WEST SUSSEX COUNTY COUNCIL CONSULTATION

TO:	Arun District Council FAO: Anita Gardner
FROM:	WSCC - Highways Authority
DATE:	5 October 2020
LOCATION:	74-76 Canada Road Arundel BN18 9HY
SUBJECT:	AB/63/20/DOC Approval of details reserved by condition imposed under ref AB/60/17/PL relating to Condition Nos 3 - materials & finishes, 4 - site set up, 7 - vehicular access onto Canada Road, 8 - vehicular access and 9 - surface water drainage. More information received.
DATE OF SITE VISIT:	n/a
RECOMMENDATION:	Advice
S106 CONTRIBUTION TOTAL:	n/a

The proposal is for the discharge of conditions 3, 4, 7, 8 & 9 (AB/60/17).

Location Plan 1:1250

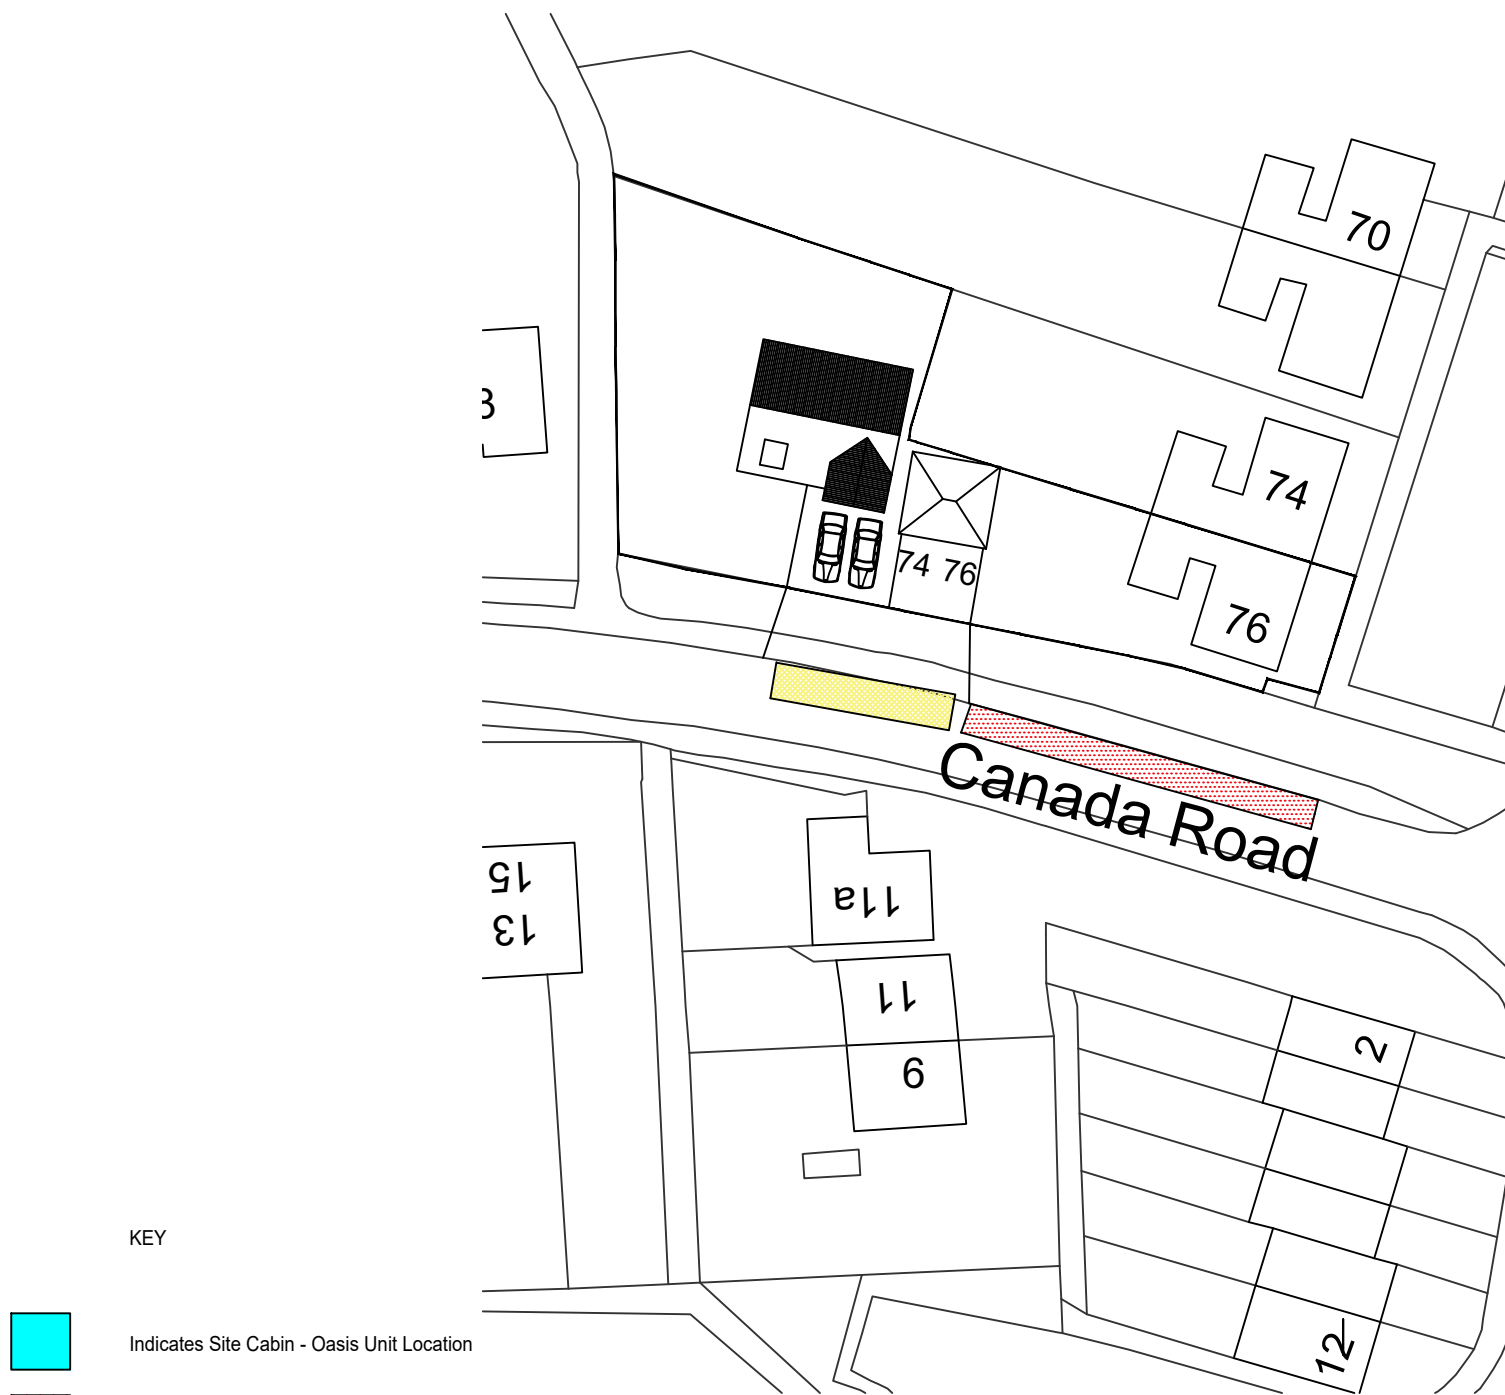
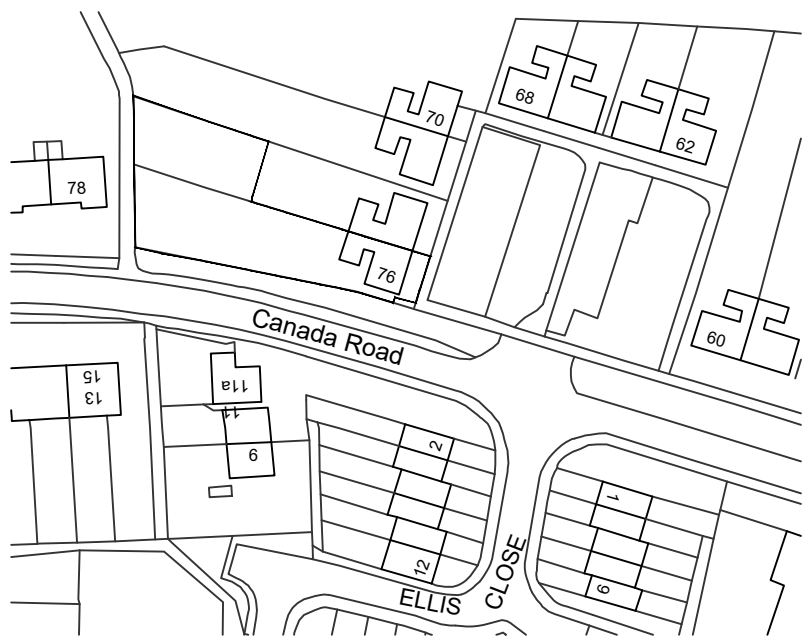
The LHA does not accept storage of materials within the publicly maintainable highway. The LHA asks the applicant to amend the plans.

The LHA does not accept parking provisions for workers within the highway, please amend.

The applicant has amended the plans to show that no parking or materials will be stored within the publicly maintainable highway. As such, the LHA are satisfied with these details.
